Addendum No. 1

RE: Contract # C203825

Jackson County (R-4753)

NC-107 From North Of SR-1002 To NC-281

PROJECT REFERENCE NO. R-4753		SHEET NO. 12	
RW SHEET NO.			
ROADWAY DESIGN ENGINEER		HYDRAULICS ENGINEER	
David J. Cloddo, PE		Stephen R. Morgan, PE	
DOCUMENT NOT CONSIDERED FINAL UNLESS ALL SIGNATURES COMPLETED

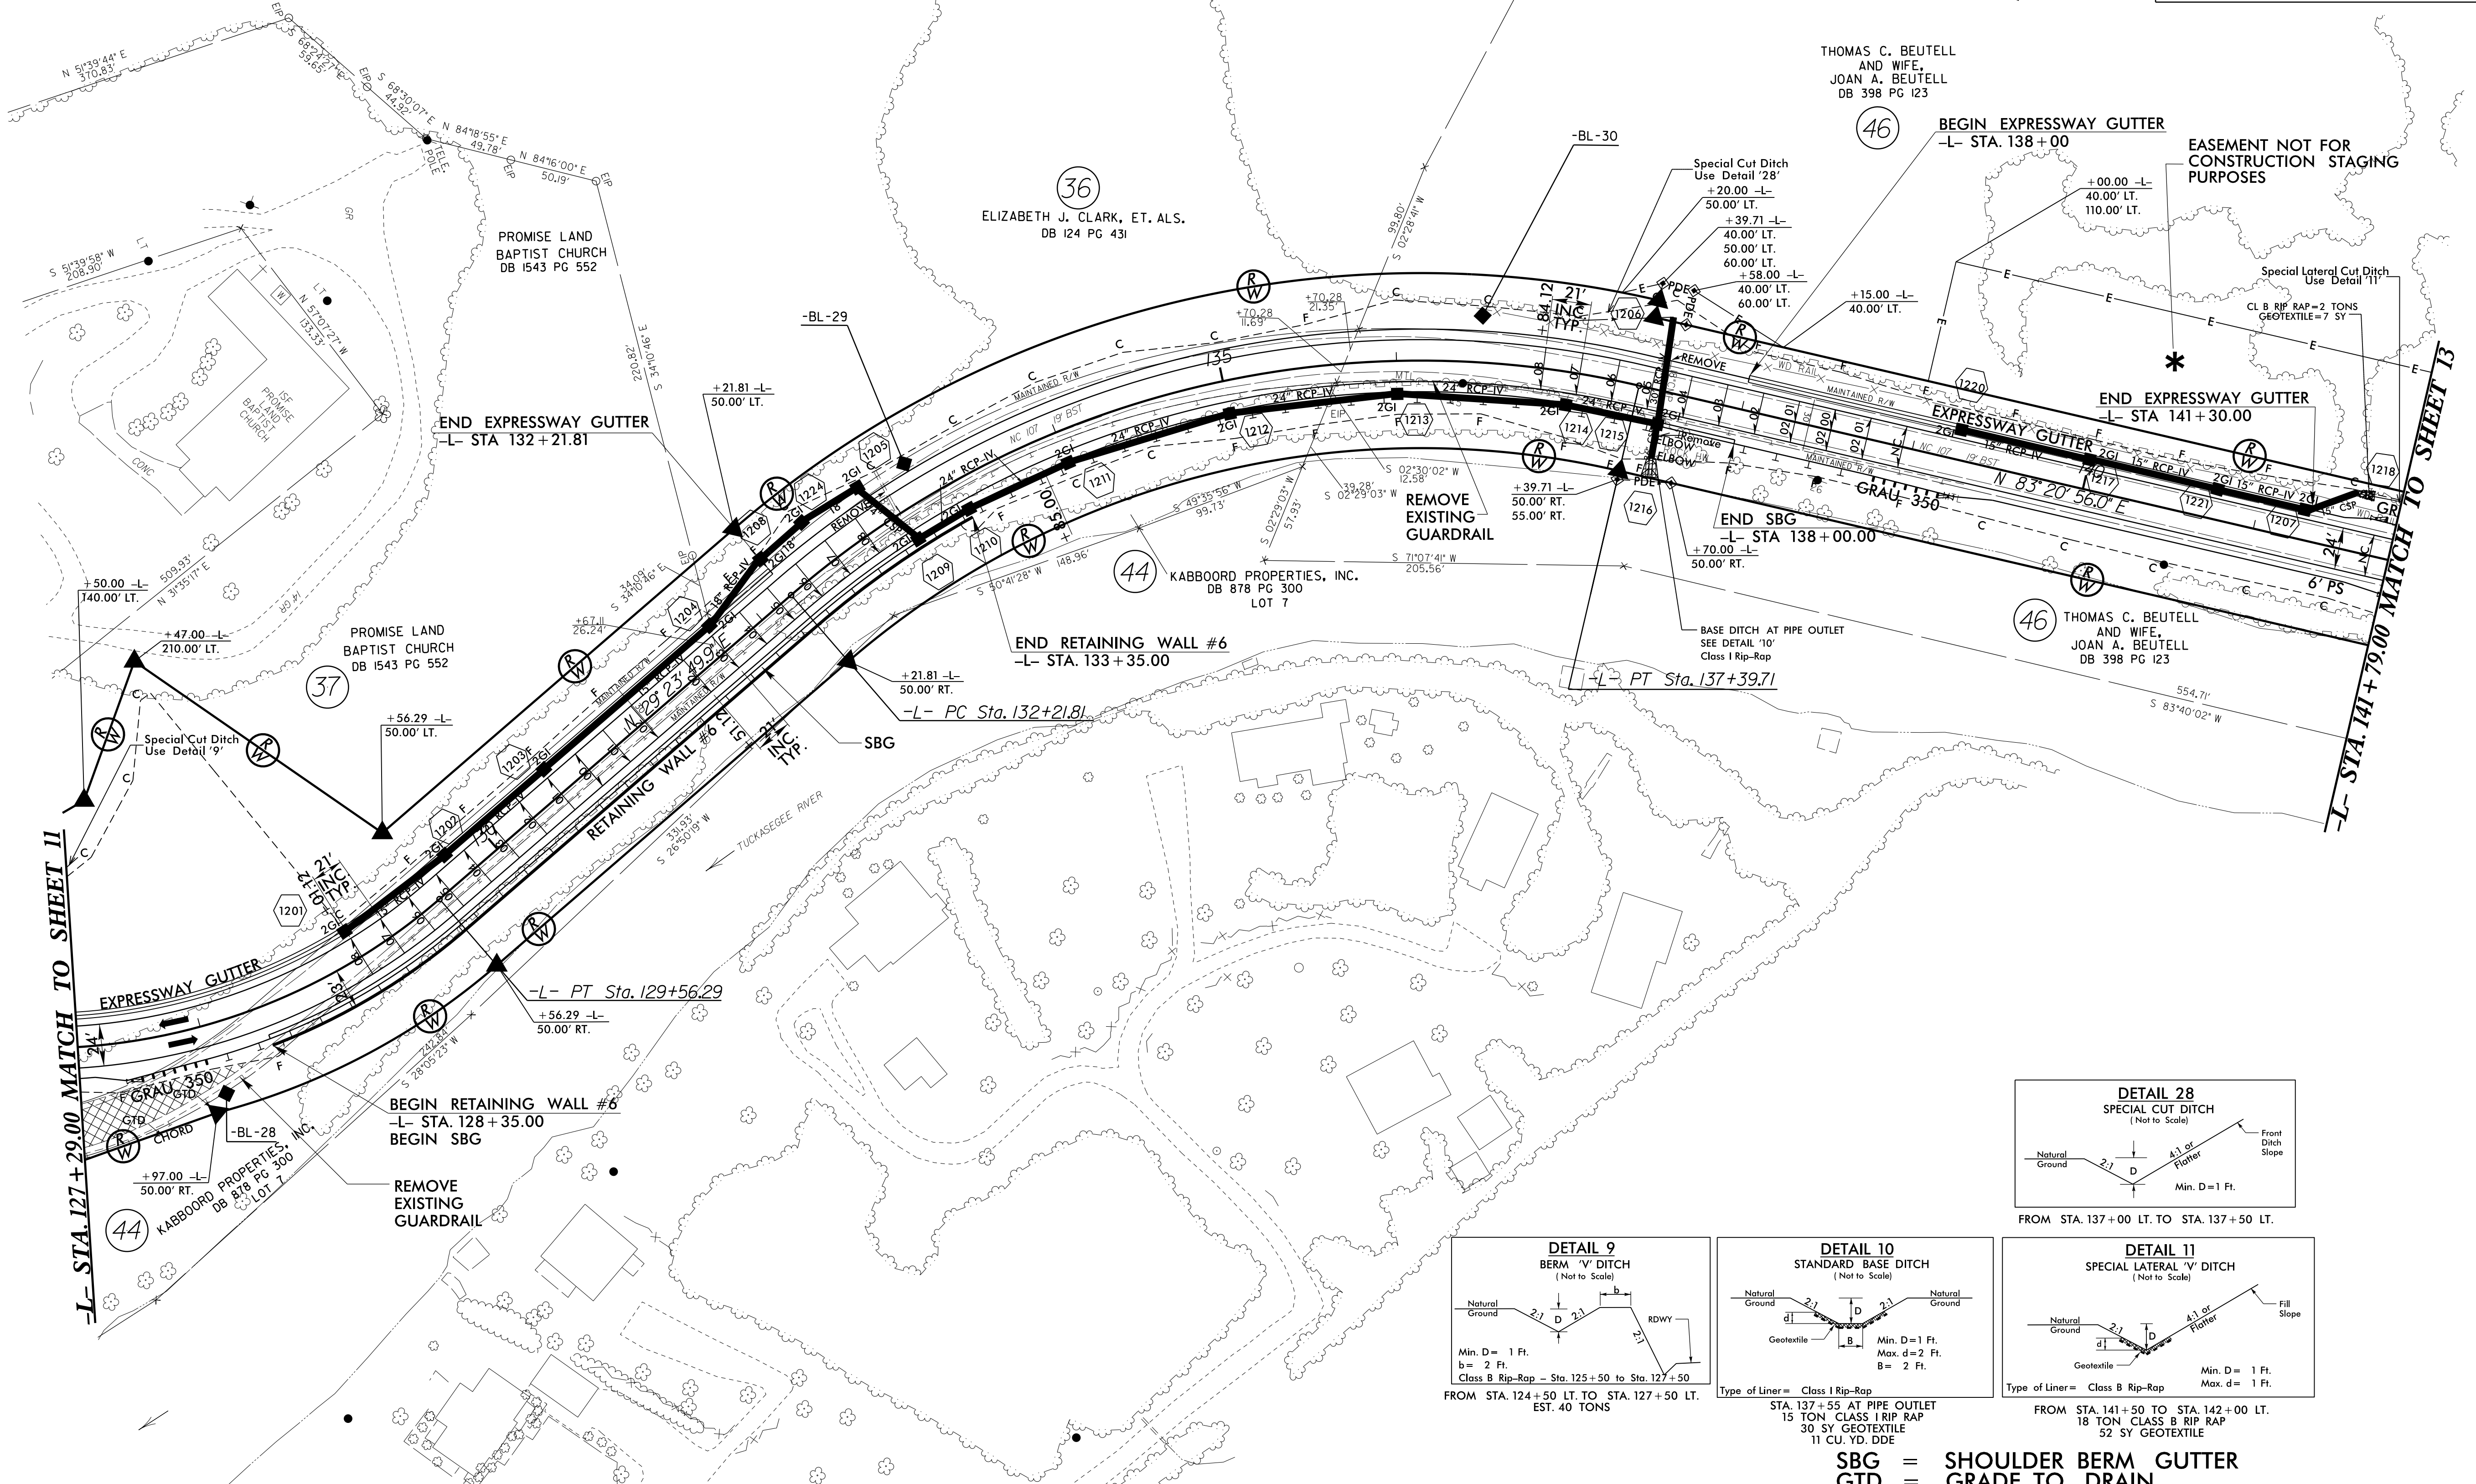
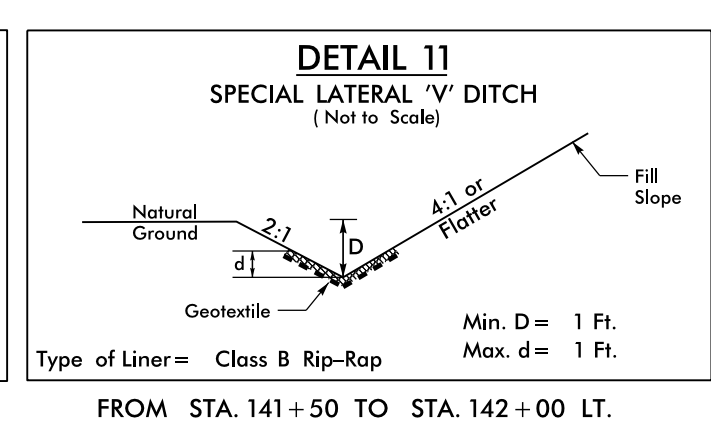
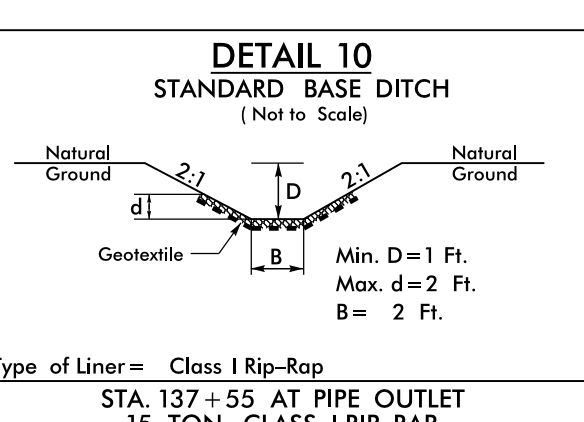
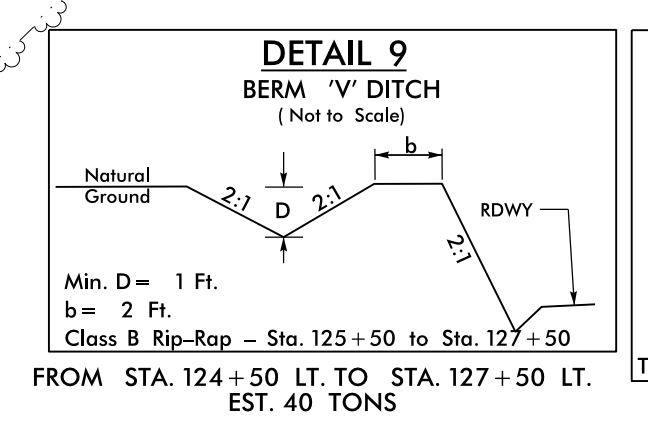
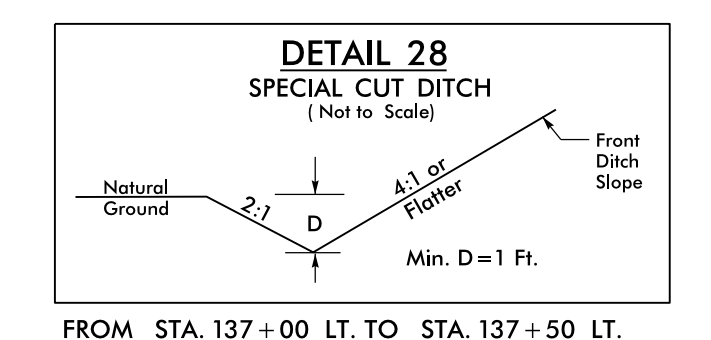
Sheet No.	Revisions
1	Revised the letting date on the Title Sheet
8, 9, 11, 12, 19 and 25	Revised or added a design exception note

| PROJECT REFERENCE NO. R-4753 | | SHEET NO. W-6 |

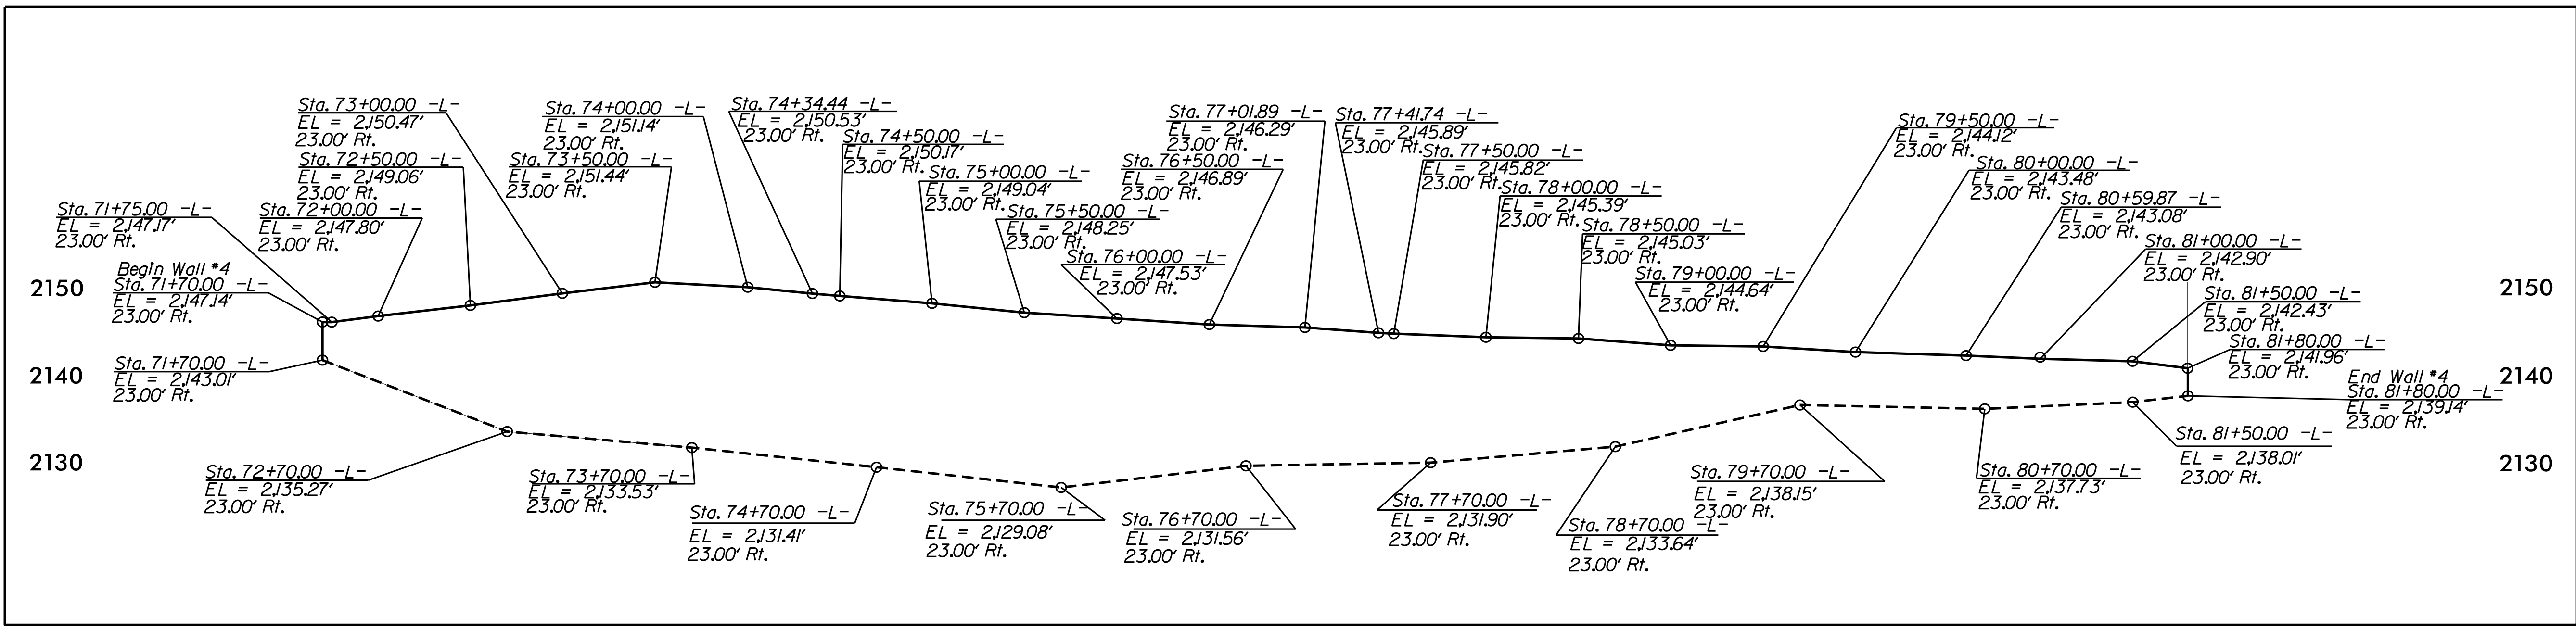
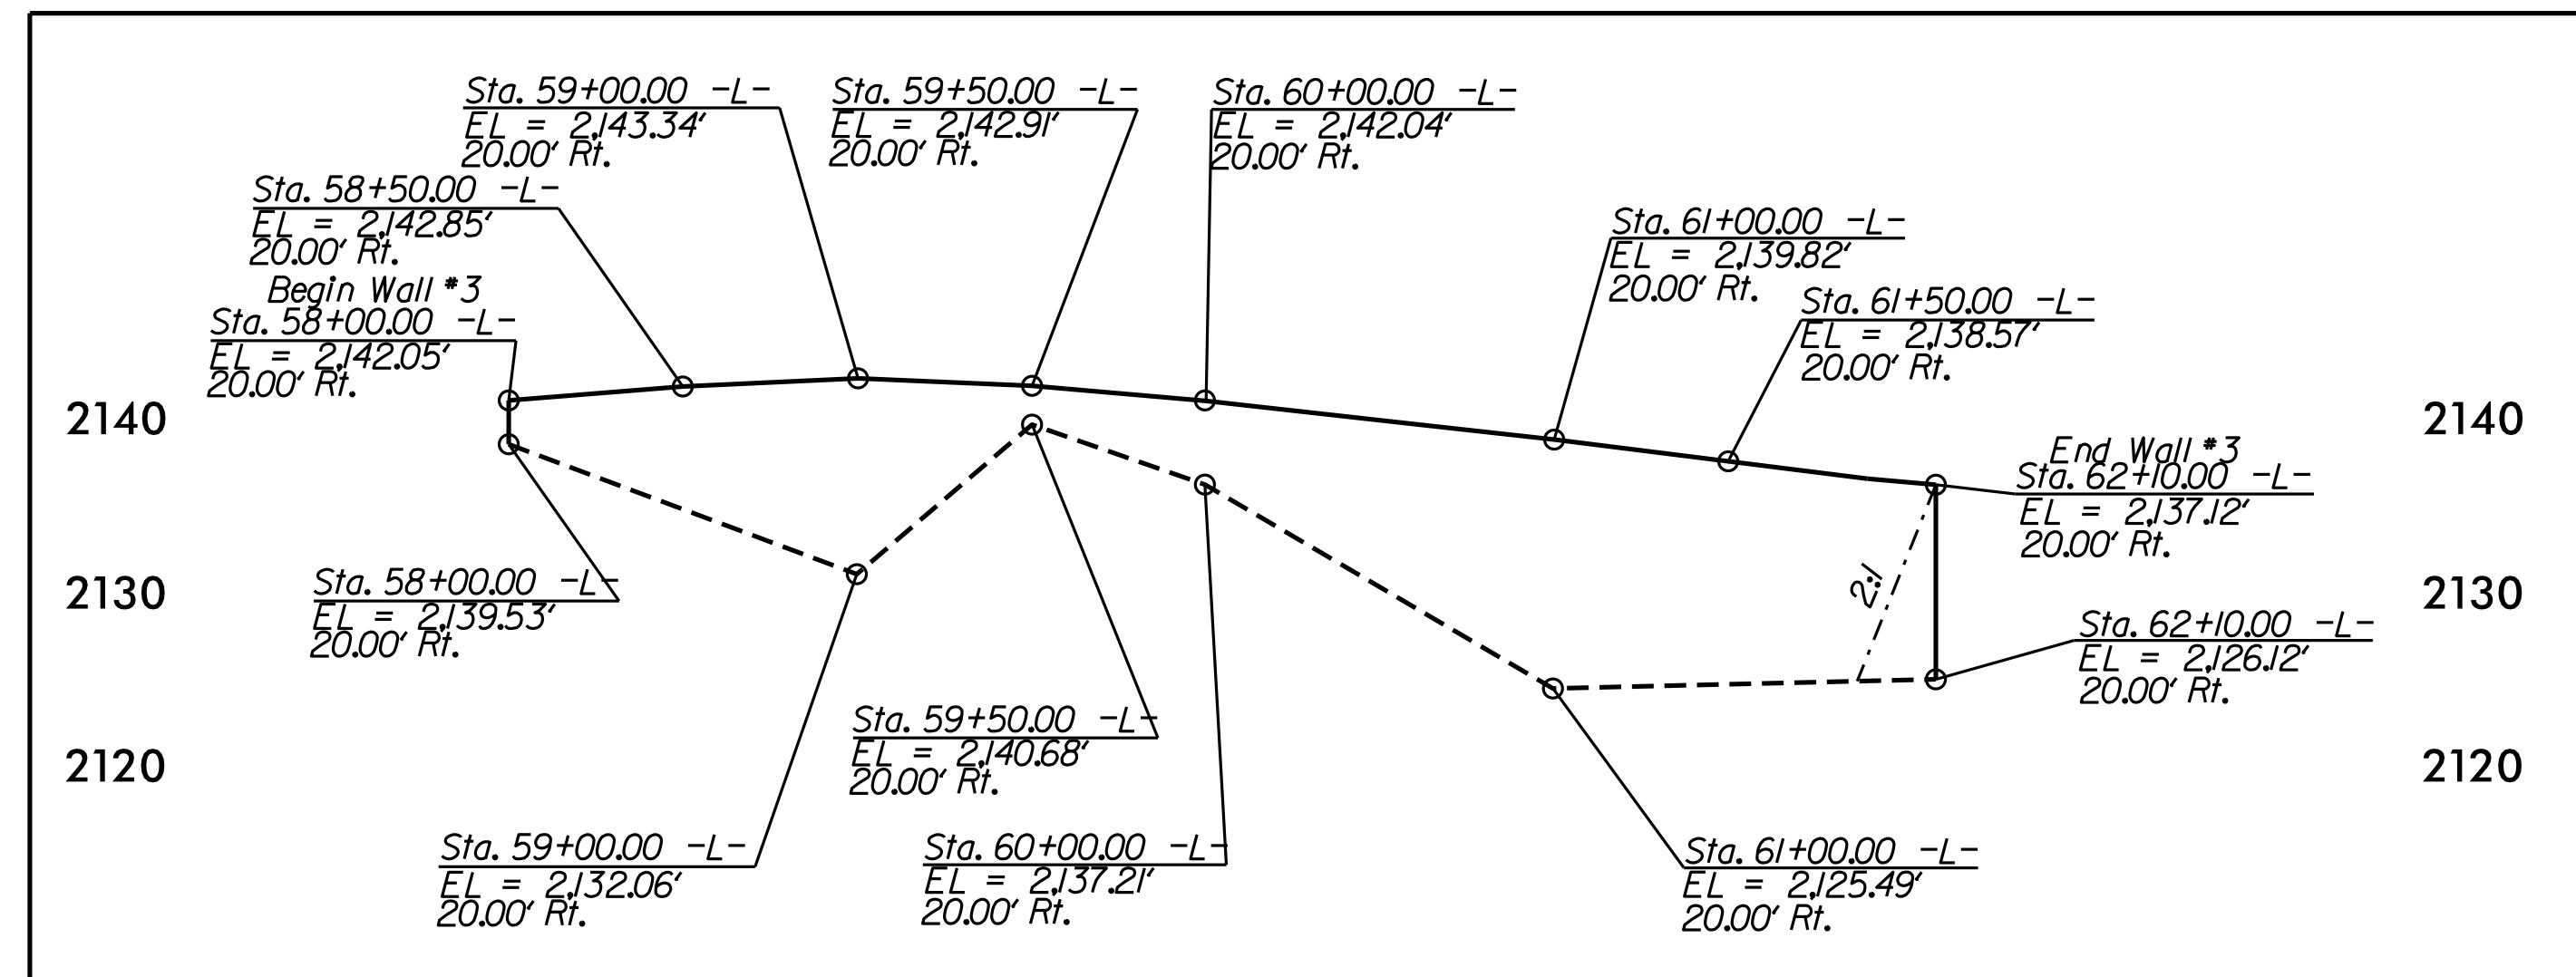
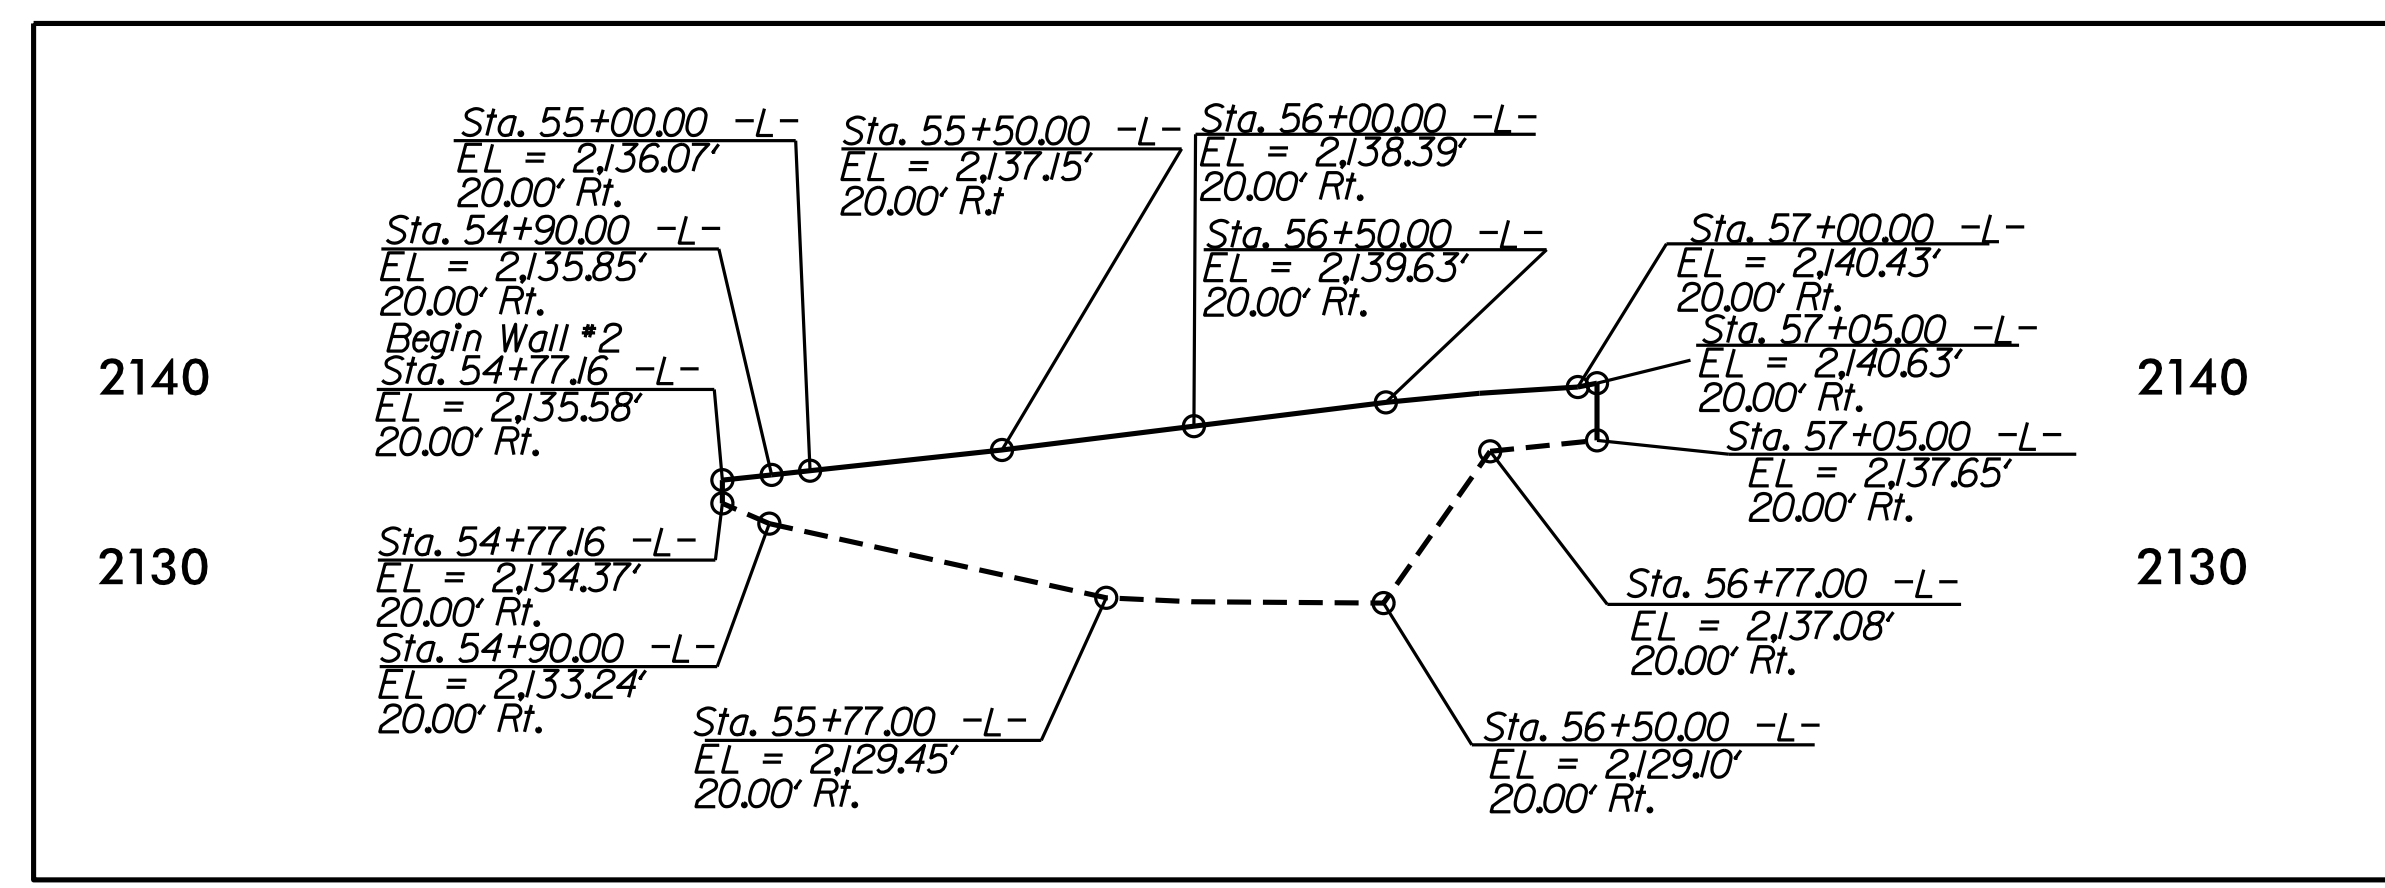
Sheet No.	Revisions
Title Sheet	Revised the letting date on the Title Sheet
W-6	Revised note No. 14
